Memo to: El Paso County PCD

From: Core Engineering Group

Date: March 14, 2018

RE: Jimmy Camp Creek Main Channel Lorson Blvd Bridge (CDR -17-7)- Review1
Response to Comments

GRADING AND
EROSION CONTROL PLAN
JCC BRIDGE AT MAIN CHANNEL

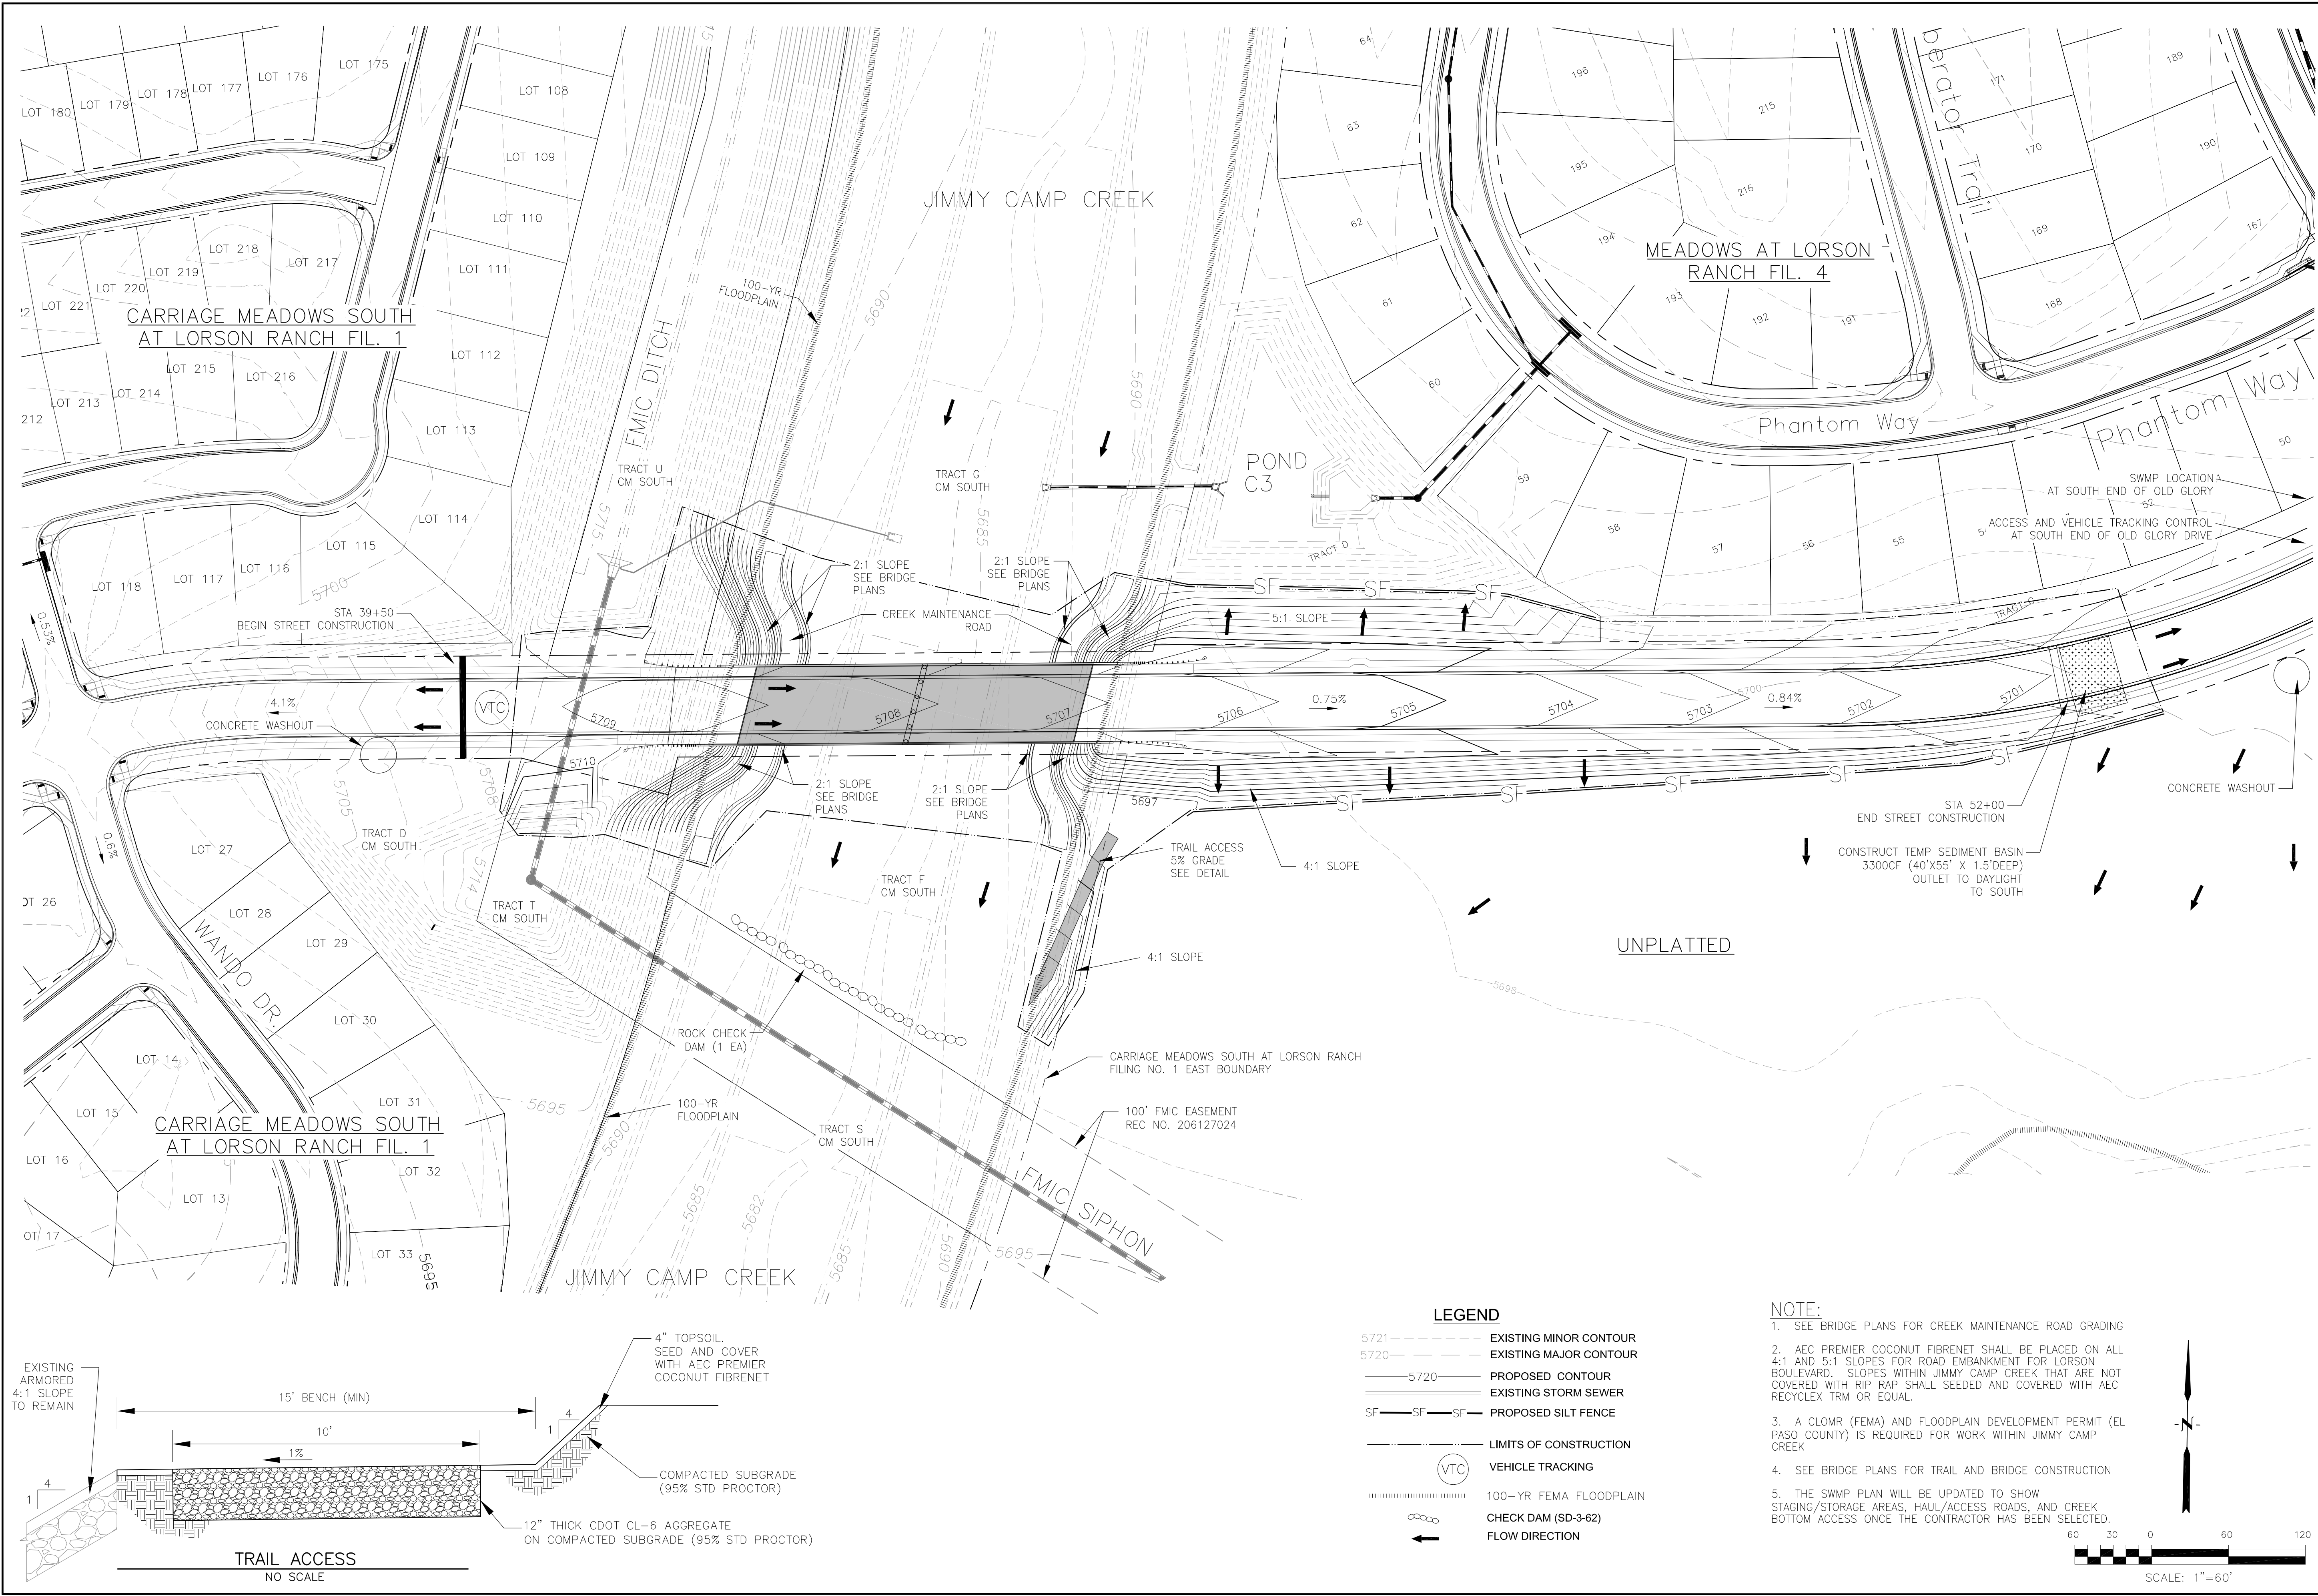
1. If the water line crossing Jimmy Camp Creek is included with bridge construction, include it in the limits of construction. **RE: limits updated for watermain**

2. Include all construction access and haul roads, staging and storage areas on the GEC Plan. If roads for equipment access need to be built to the channel bottom, include description of the locations, design and restoration in the SWMP narrative and show on the GEC Plan. **RE: access shown on plan. Narrative added to indicated contractor to provide haul road and access to bottom of channel in their swmp.**
